MEMORANDUM

DATE: 06/29/2021

SUBJECT: **On-Call Contract #17-067H-1; PO # 8113073**
Bridge Reviews
Task Order #6: Mesa Top Bridge Submittal - Third Review

BRIDGE HYDRAULIC SECTIONS

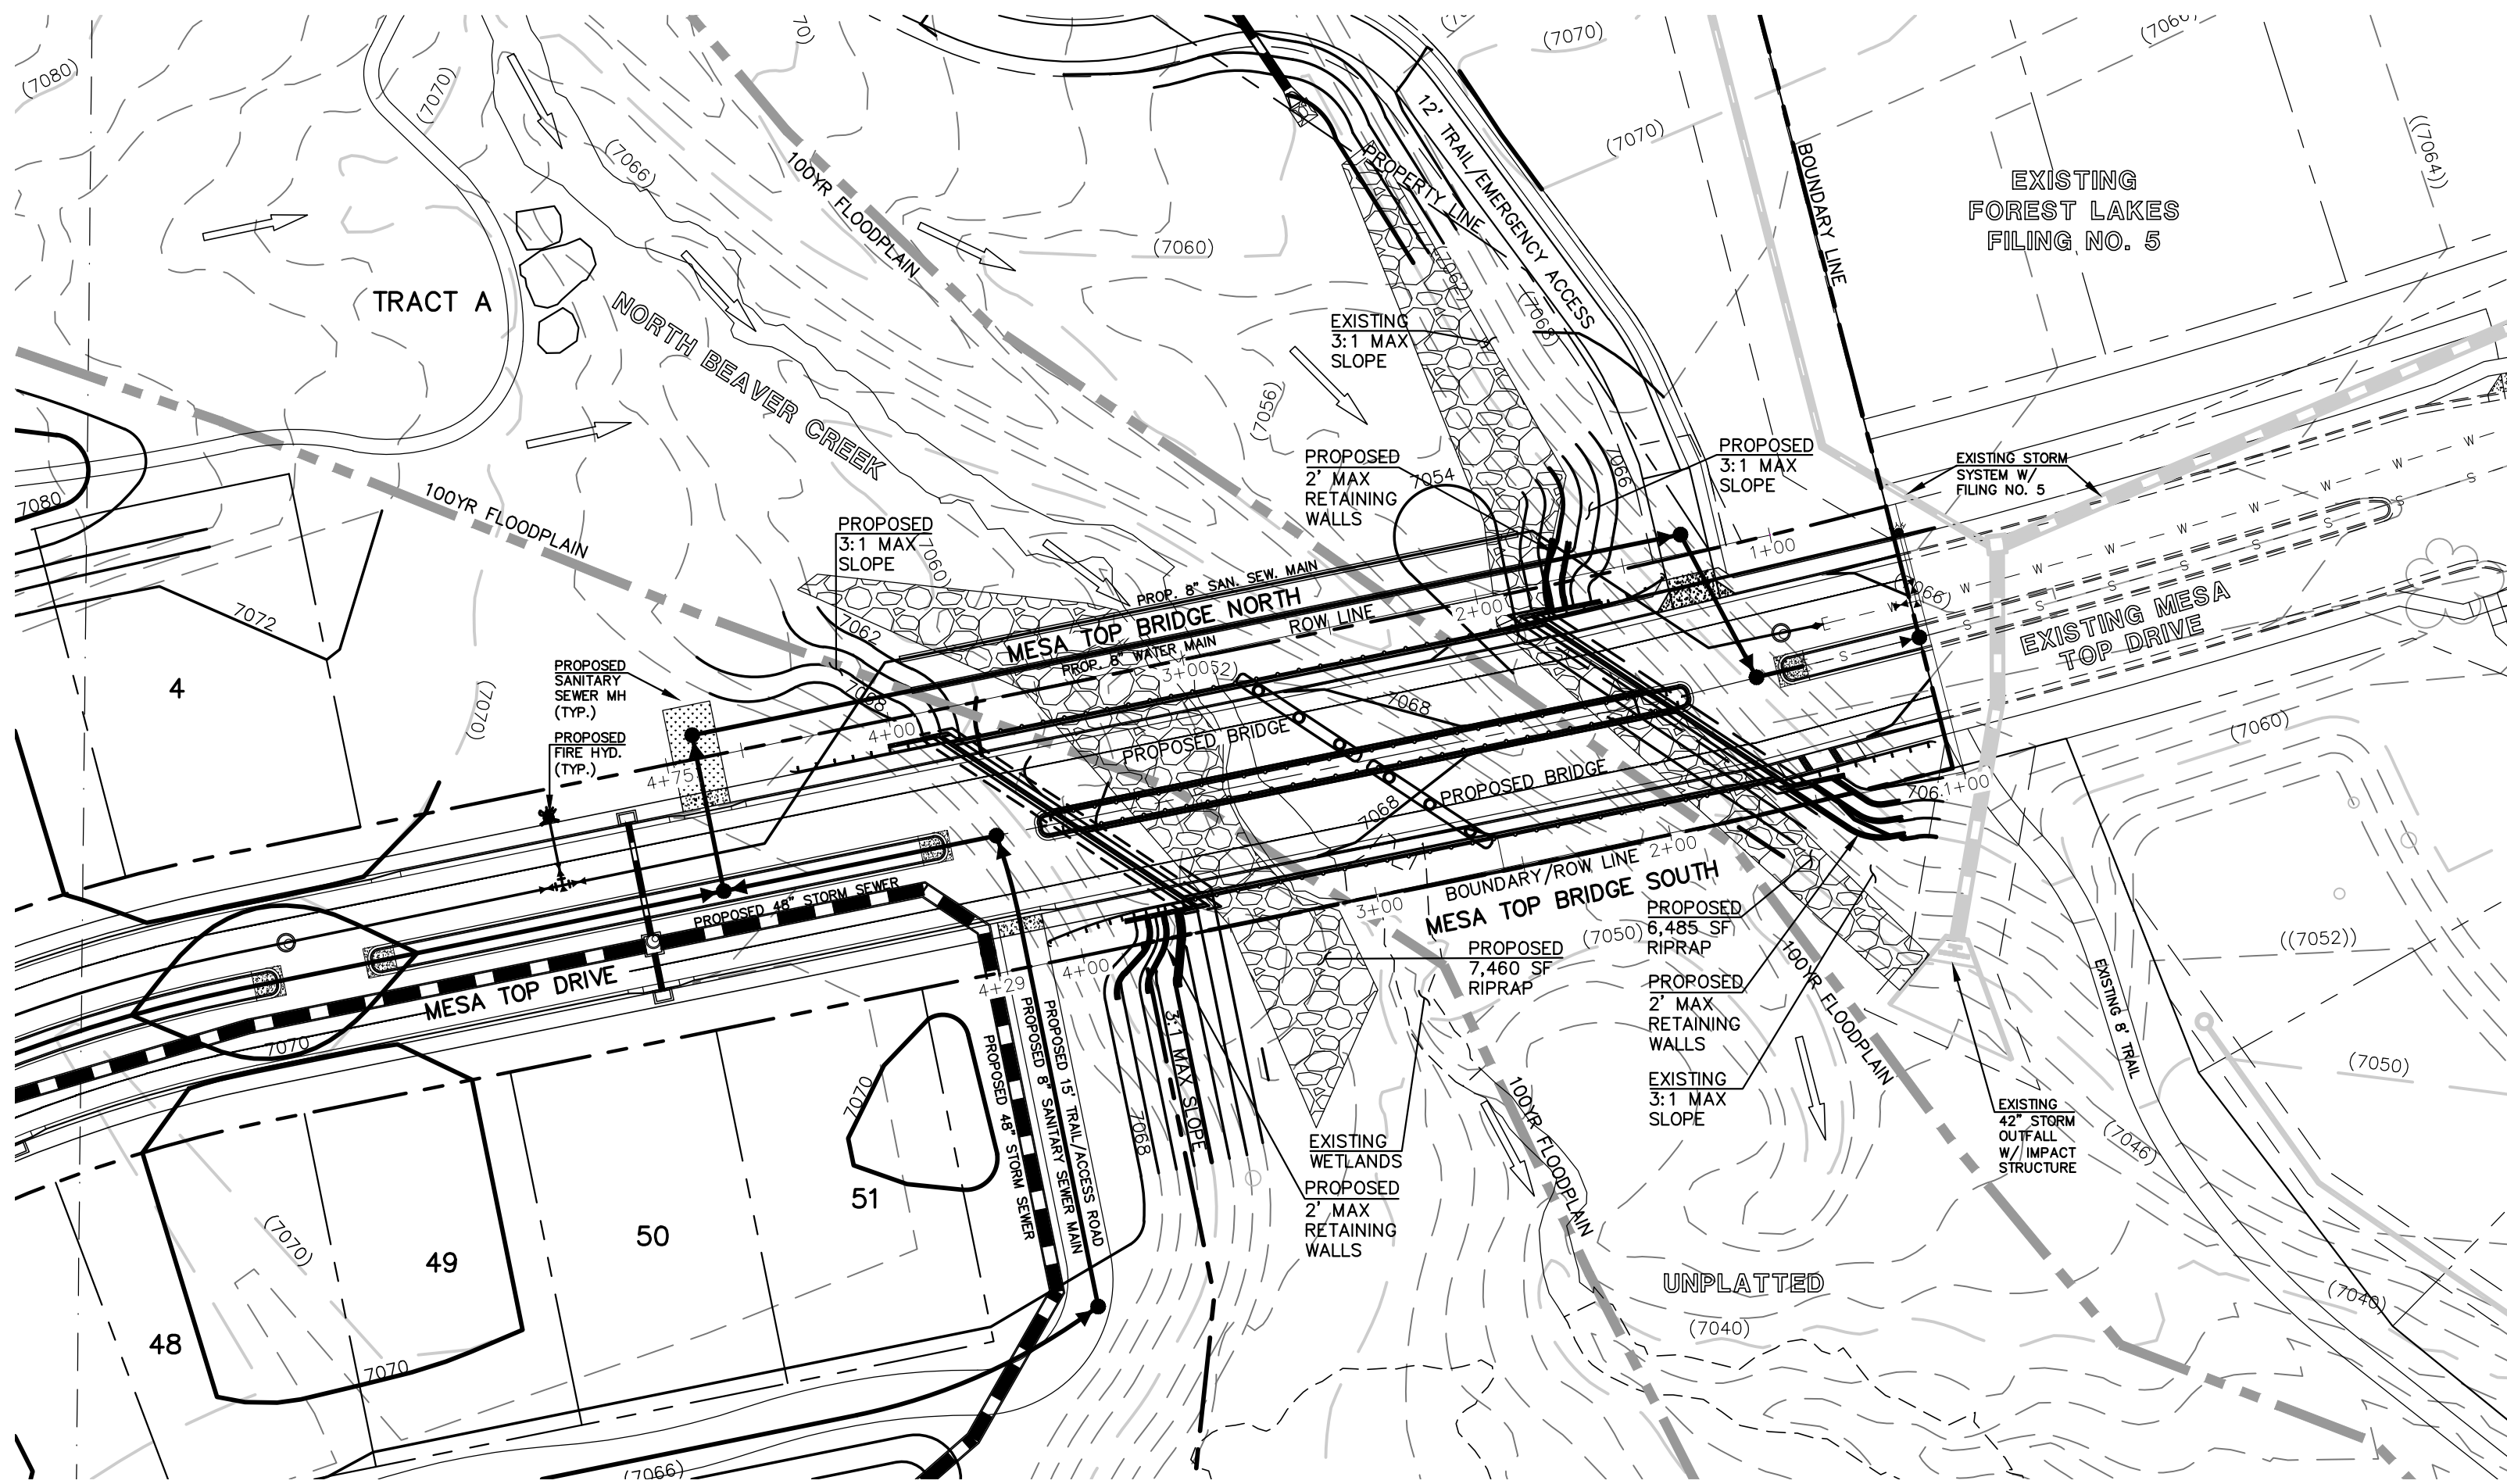
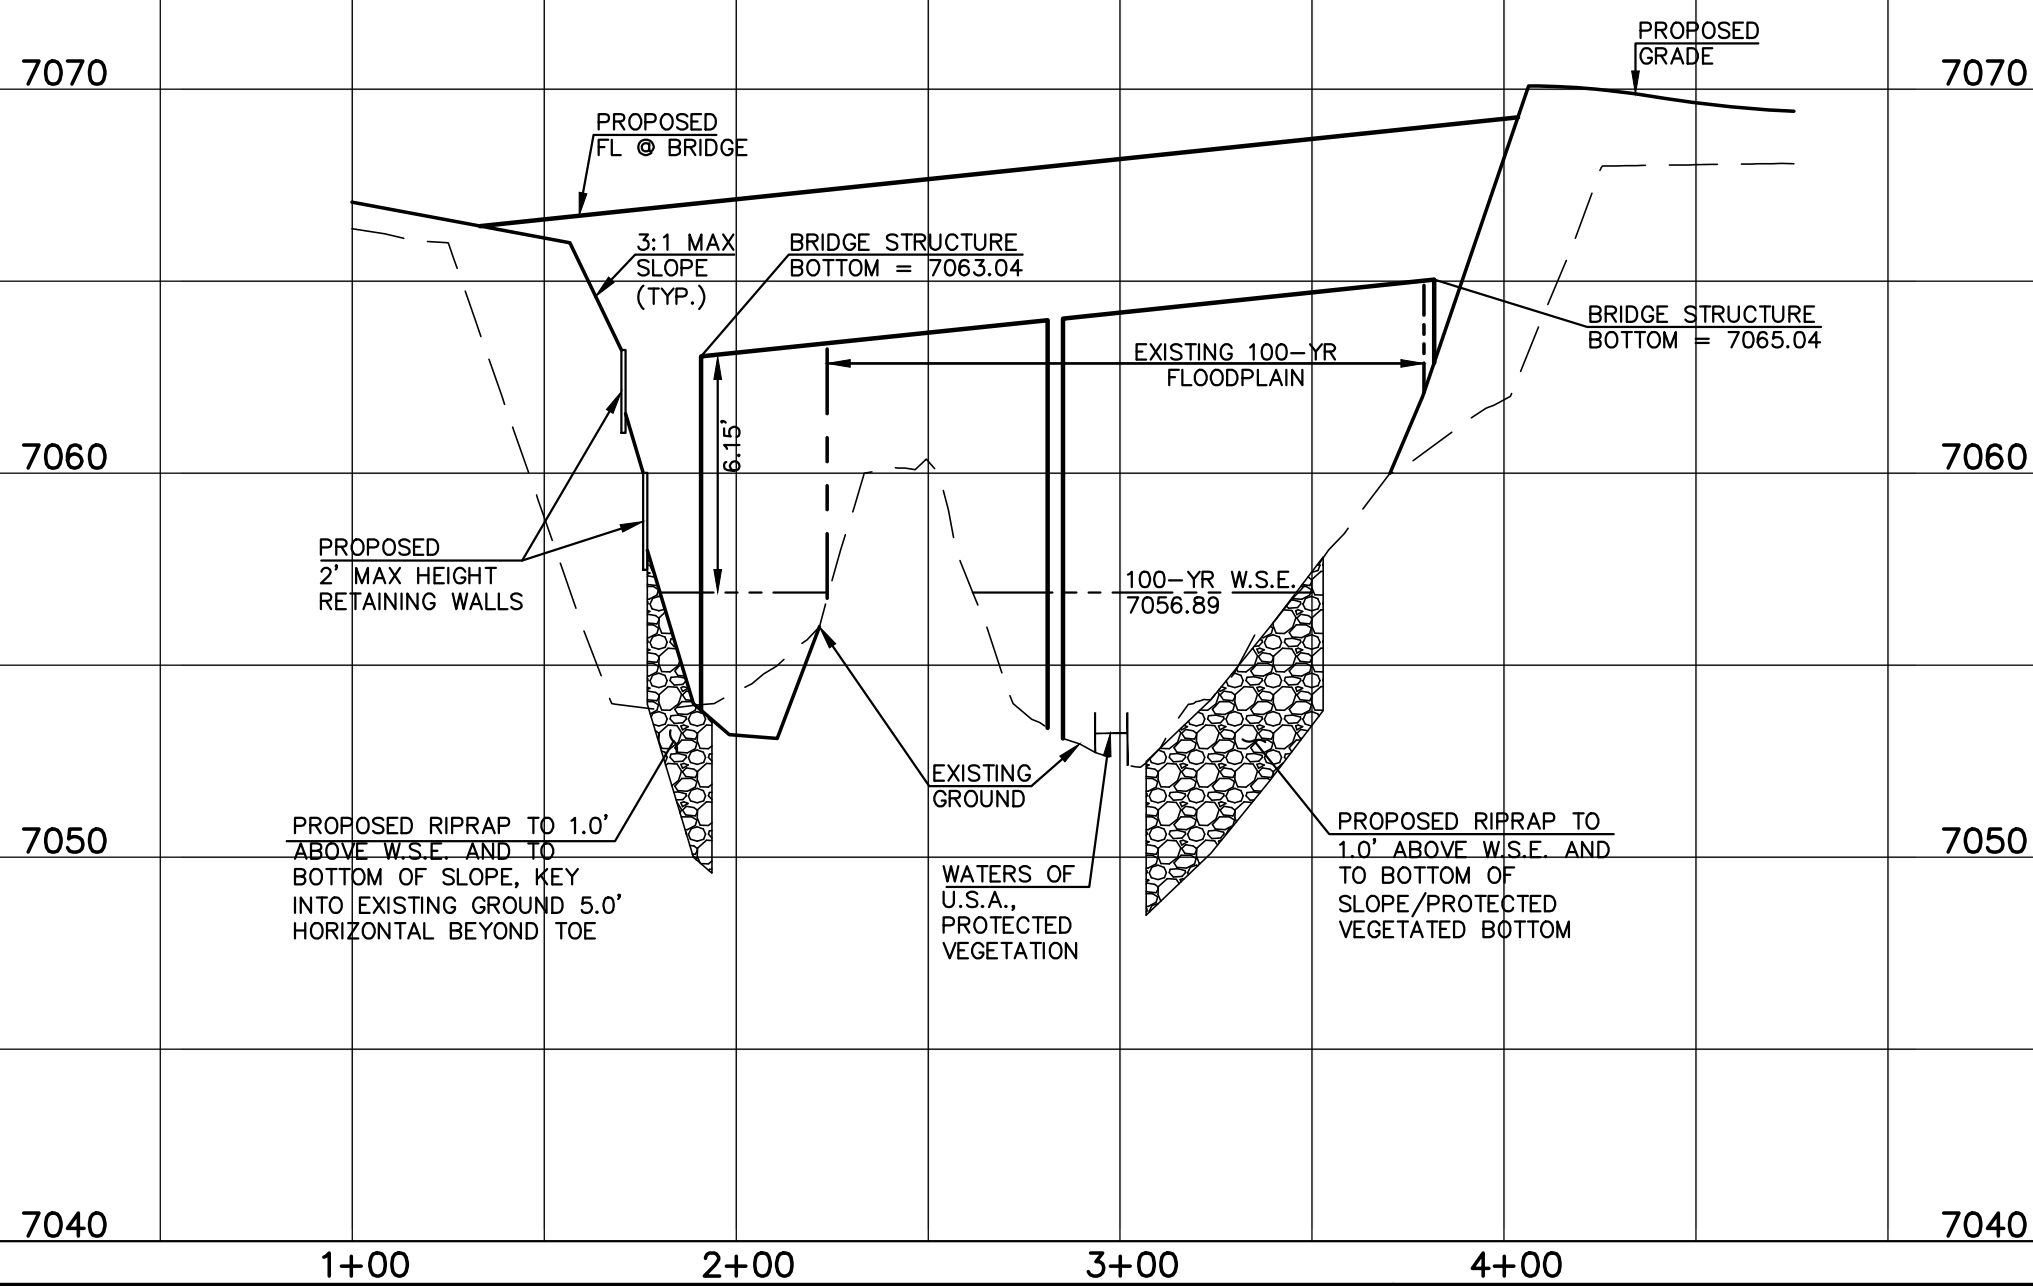
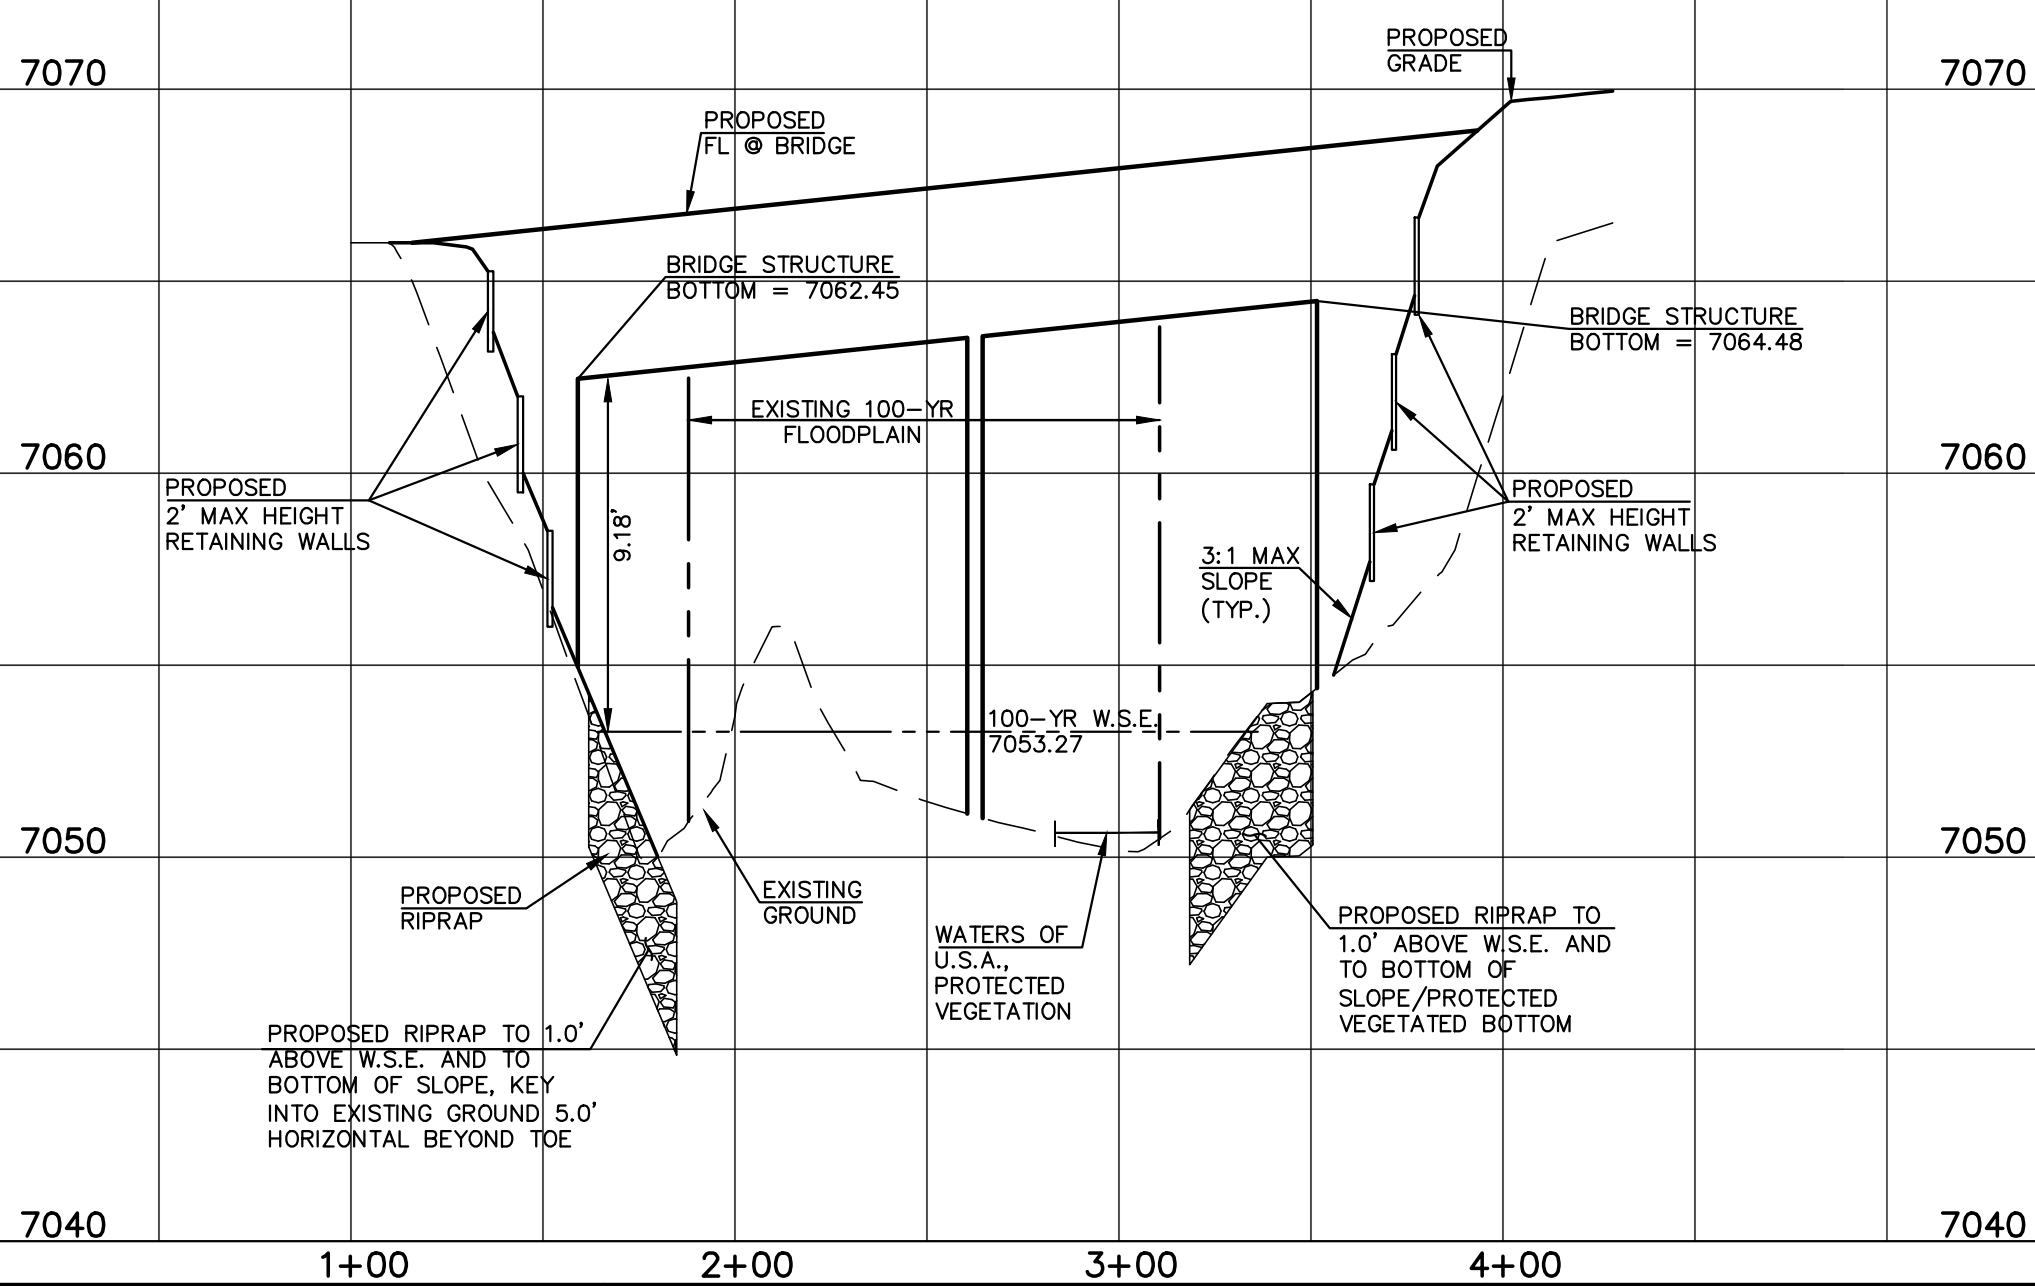
1. How are the plan view limits of riprap being defined? What is the riprap size? Is there bedding or geotextile proposed? (Comment 1 from this section in Second Review memo). Did not see any updates on this
2. Show scour limits. (Comment 2 from this section in Second Review memo). Did not see any updates on this
